MP-2007/70/A

Development	Demolition of the existing structures, construction of a signalised intersection and development of a new 8 storey, 154 bed, medical and health facility (Wollongong Private Hospital) – Modification 1
Location	364 Crown Street, WOLLONGONG NSW 2500, Cram House, 360-362 Crown Street, WOLLONGONG NSW 2500, 9 Urunga Parade, WOLLONGONG NSW 2500, 11 Urunga Parade, WOLLONGONG NSW 2500

I refer to your letter dated 19 July 2013 seeking Council's comment in regard to the Donald Cant Watts Corke Pty Ltd (the proponent) request to modify the above project pursuant to Section 75W of the Environmental Planning and Assessment Act 1979.

Council has reviewed the modified proposal and raises no objection to the proposed changes; however the following comments/conditions as attached are requested to be considered in the Department's assessment of the modified proposal.

CATCHMENT PLAN - PRE-DEVELOPMENT

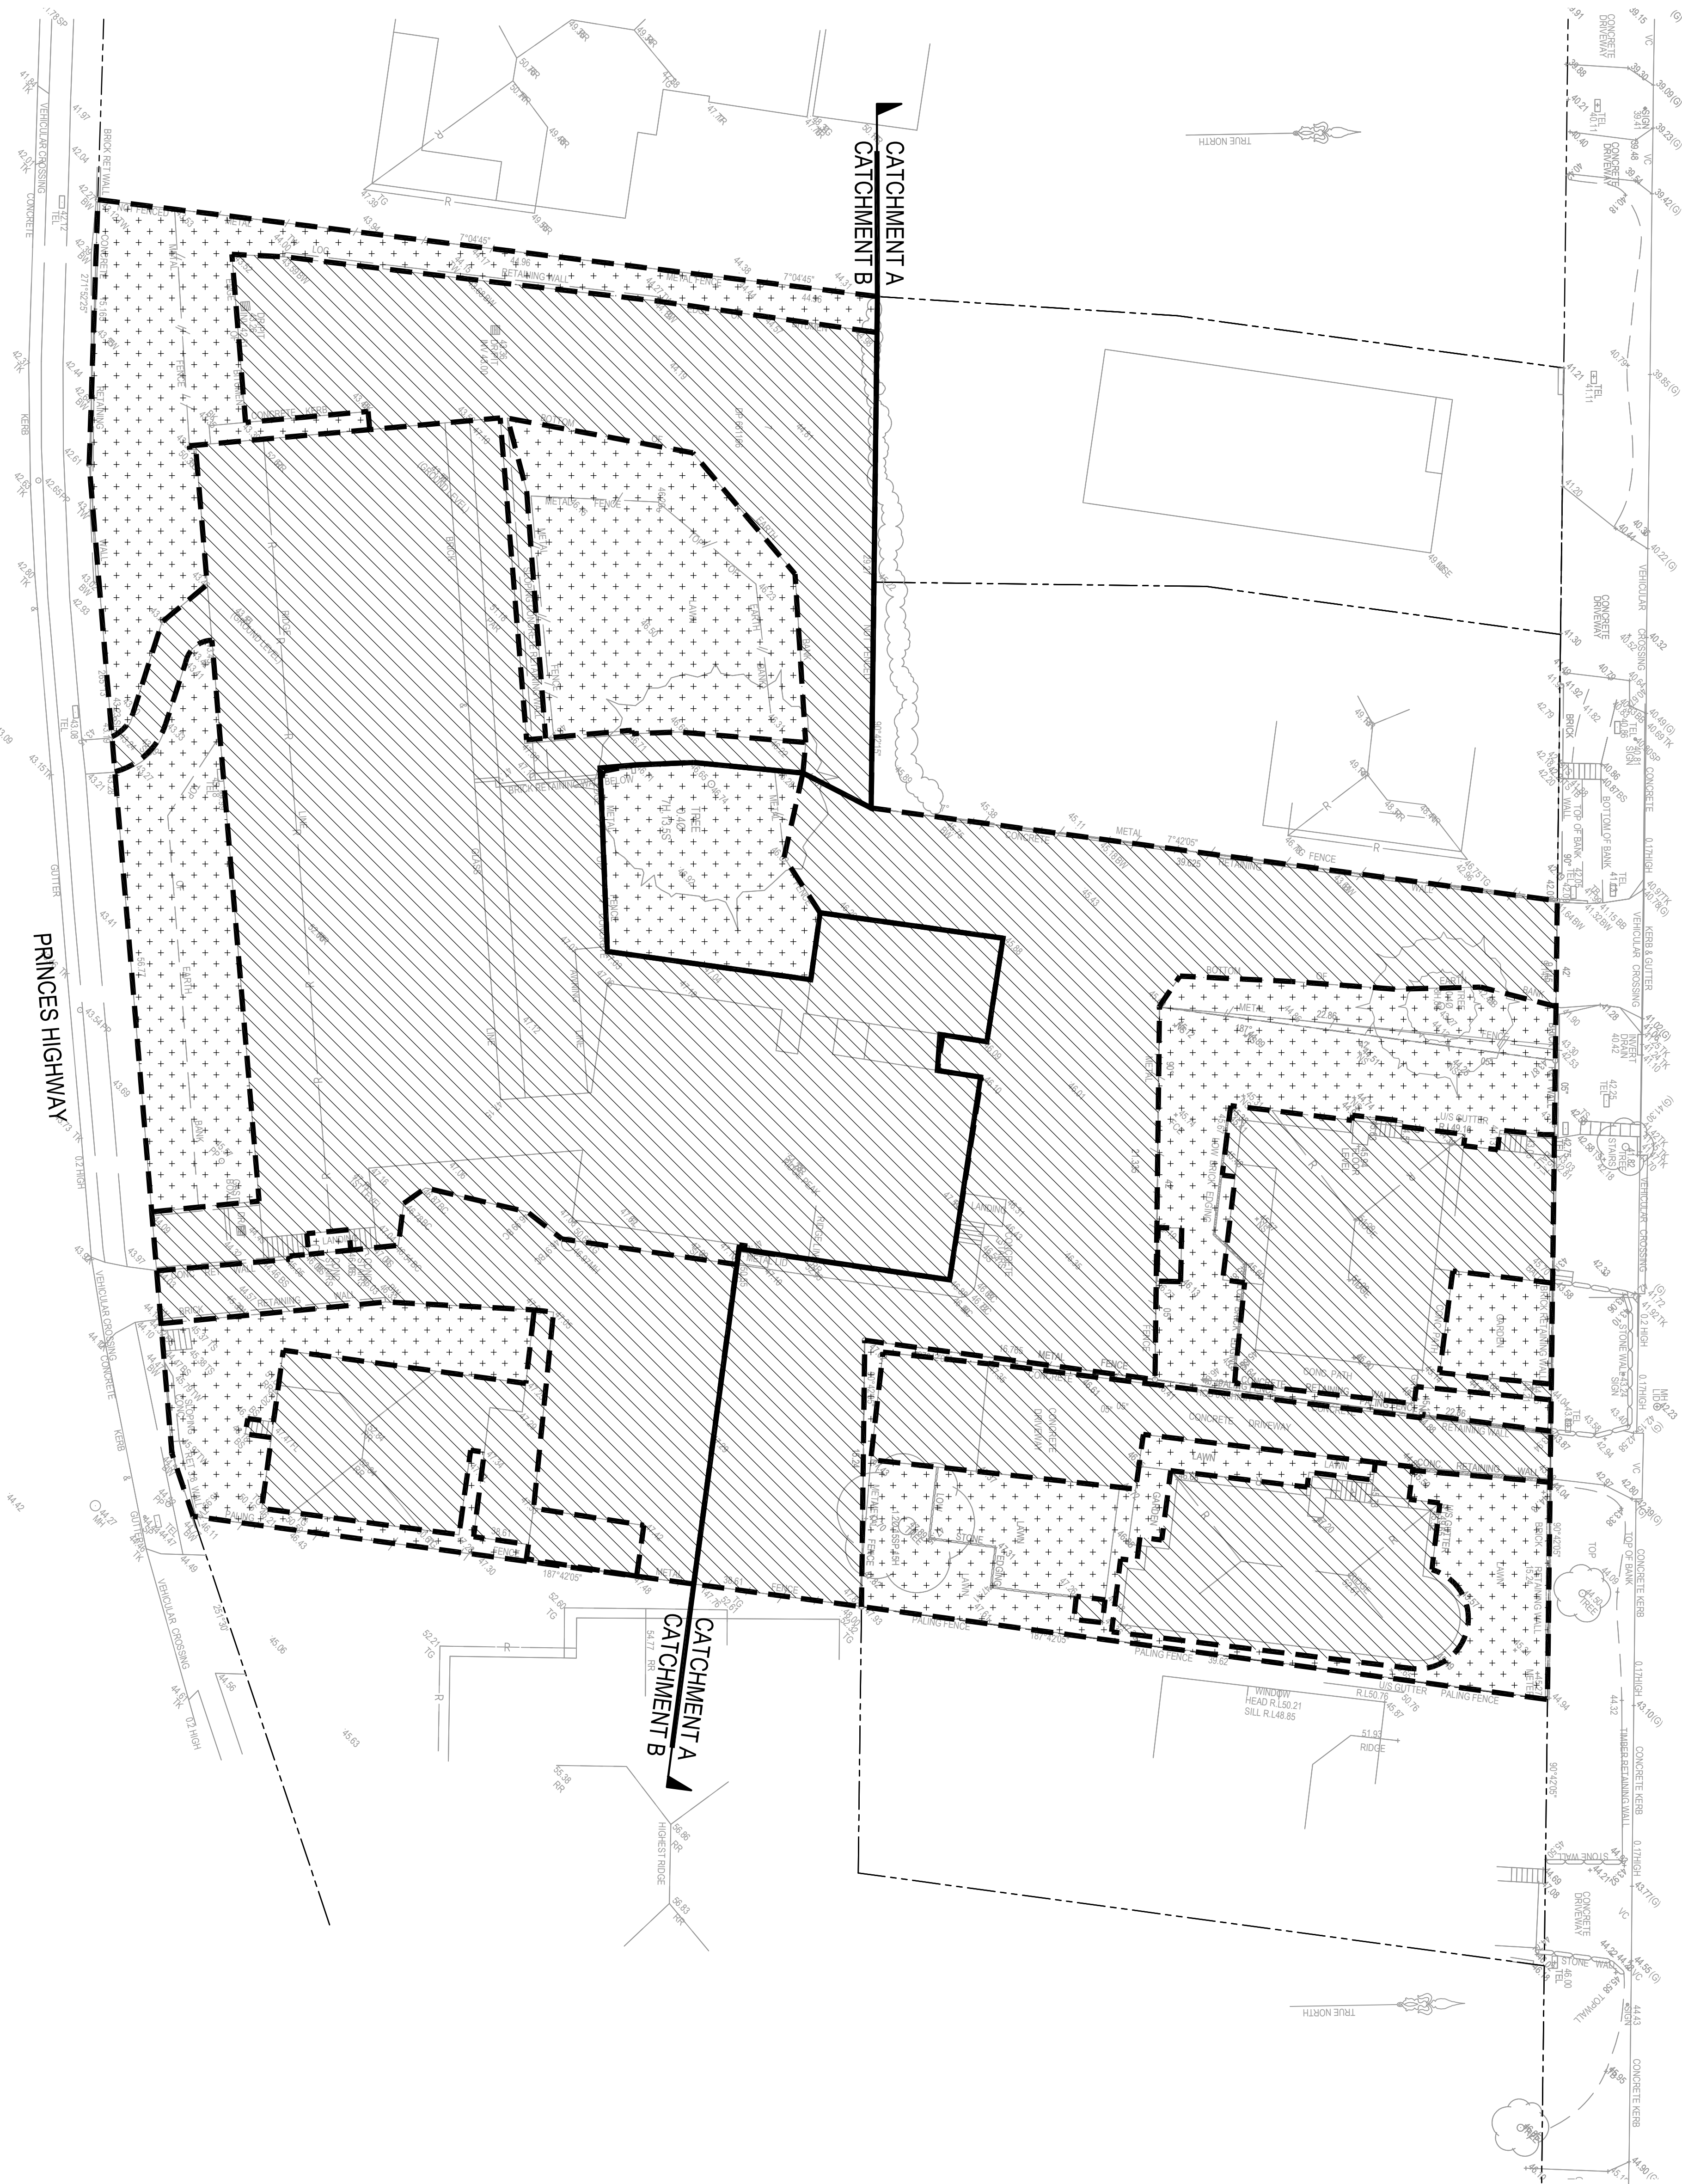
3. Stormwater	
	<p>Section 5.6 of the report by McKenzie Group Consulting Planning dated July 2013 indicates that on-site detention is now considered necessary due to the increase in impervious area (assumed for catchment B). However there is no increase in impervious area for Catchment B according to the civil plans by Henry & Hymas, which actually show a decrease in impervious area from the pre-developed case.</p> <p>The on-site detention system proposed for Catchment ‘B’ is in conflict with the landscape plan. In particular the ‘StormTech’ chamber detention system is in conflict with the feature trees proposed along the Crown Street frontage. The proximity to the trees has the potential to significantly damage the detention system and result in a loss of integrity of its main functions to detain stormwater and convey flows to the street.</p> <p>Other potential issues with the proposed chamber detention system include difficulties with access and maintenance, the inability to detain stormwater due to the permeable membrane, and the potential loss of available storage volume due to the ingress of surrounding groundwater flows through the permeable membrane.</p> <p>With respect to the above items, an alternate stormwater management design is required for Catchment ‘B’. It is requested the alternate design be submitted to Council for further review prior to the issue of the modified Project Approval.</p>

DRAWING TITLE  
LANDSCAPE CONCEPT PLAN  
FIFTH FLOOR

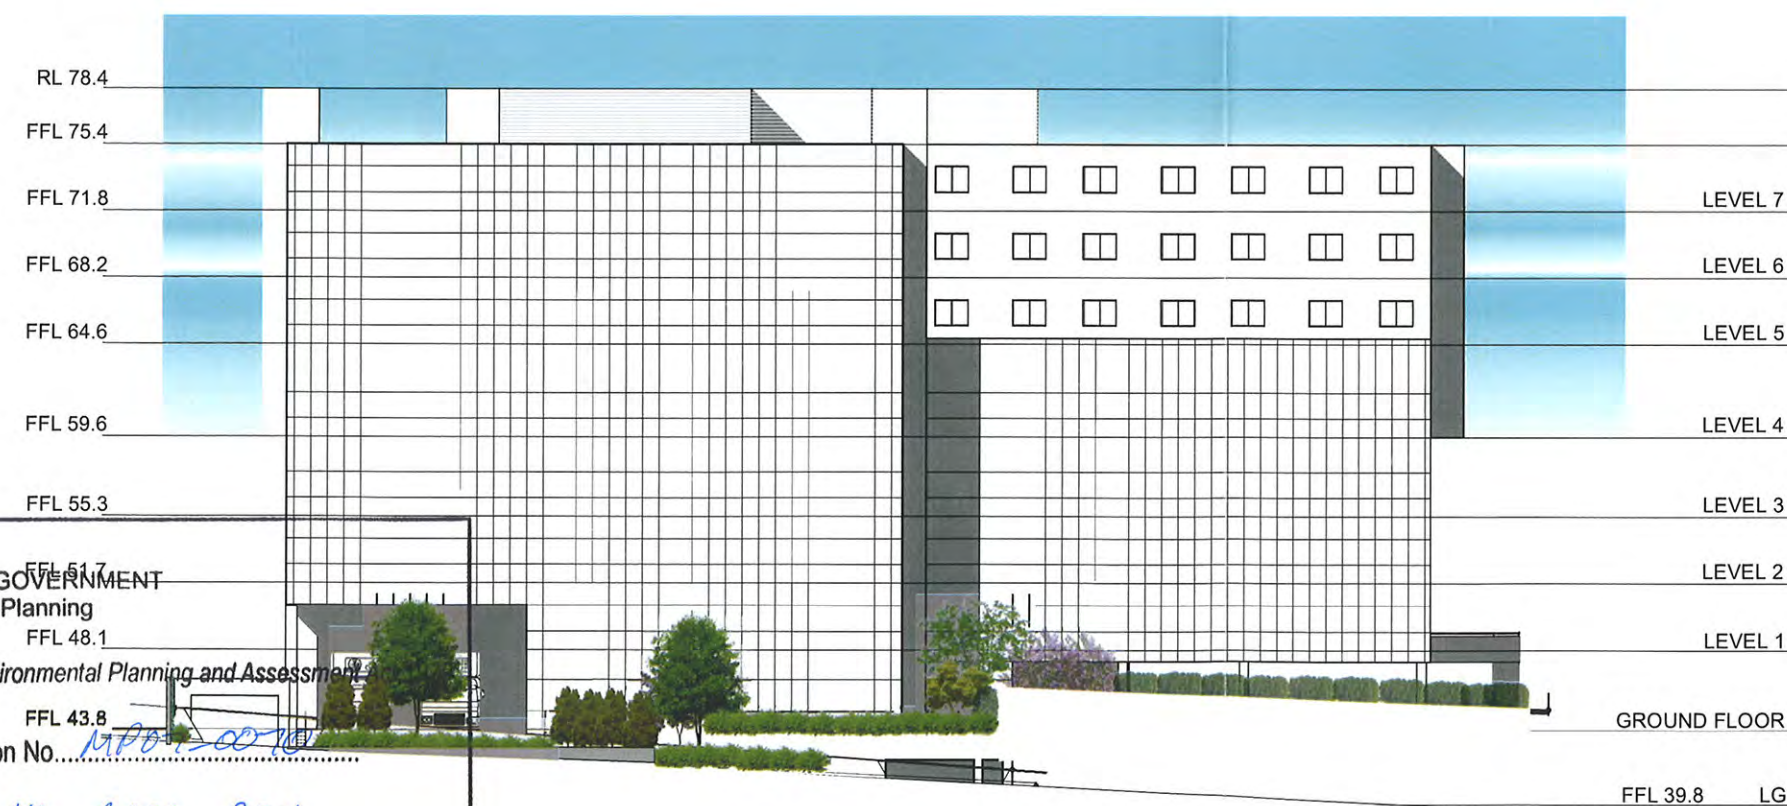
4. Landscape	
	Requested conditions
4a	<p>Trees to be Removed</p> <p>The developer has permission to remove the existing trees on site as indicated on the submitted Landscape Concept Plan by Context.</p>
4b	<p>Footpath Pavement</p> <p>The developer is responsible for the construction of footpath paving for the entire frontage of the development. The footpath must be installed to the satisfaction of WCC. A minimum two percent (2%) maximum two and a half percent (2.5%) cross fall to be provided from property line to back of kerb. This requirement shall be indicated on the final Landscape Plans submitted to the Principal Certifying Authority, prior to the release of the construction certificate.</p>
4c	<p>Pavement – Crown Street and Urunga Parade:</p> <p>Main body of pavement to be ‘Sante Fe, Illiad’ by Adbri Masonry Pty Ltd (or approved equivalent) dark grey, honed finish, 300 x 300 x 50mm. Contrasting band to be ‘Sante Fe, Off White’ by Adbri Masonry Pty Ltd (or approved equivalent) ivory coloured paving unit, honed finish, 300 x 300 x 50mm.</p> <p>Driveway pavement to be ‘Brickpave, Illiad’ by Adbri Masonry Pty Ltd (or approved equivalent) dark grey, honed, 230 x 113 x 80mm paving units in a herringbone pattern, contrasting band to be Hanson ‘Brickpave, Off White’ (or approved equivalent) ivory coloured paving unit, honed finish, 230 x 113 x 80mm.</p> <p>Samples to be approved by WCC Infrastructure Division.</p> <p>Sealant:</p> <p>Penetrating sealer ‘Uni Seal’ by Spirit Marble & Tile Care Pty Ltd (or approved equivalent).</p>

4d	<p>Street Trees</p> <p>Provide street tree planting to Urunga Parade, species <i>Elaeocarpus reticulatis</i>, size 200L at shown</p>

on the Landscape Concept Plan. Tree pits must be detailed in accordance with the Public Domain Technical and installed to the satisfaction of WCC Manager City Works. Contact Dial Before You Dig and undertake any necessary pot holing to determine the location of existing services before excavating tree pits. This requirement shall be reflected on the Construction Certificate plans and any supporting documentation
4e	Final Landscaping Plan The submission of a final Landscape Plan in accordance with the requirements of Wollongong City Council Landscape DCP 2009 Chapter E6 Landscape and in accordance with the approved Landscape Plan (ie as part of this consent) for the approval by the Principal Certifying Authority, prior to the release of the Construction Certificate.
4f	Provisions of Taps/Irrigation System The provision of common tap(s) and/or an irrigation system is required to guarantee that all landscape works are adequately watered. The location of common taps and/or irrigation system must be indicated on the Landscape Plan for the Construction Certificate, as detailed in the Wollongong City Council Landscape Technical Policy No 98/4. This requirement shall be reflected on the Landscape Plan prior to the release of the Construction Certificate.
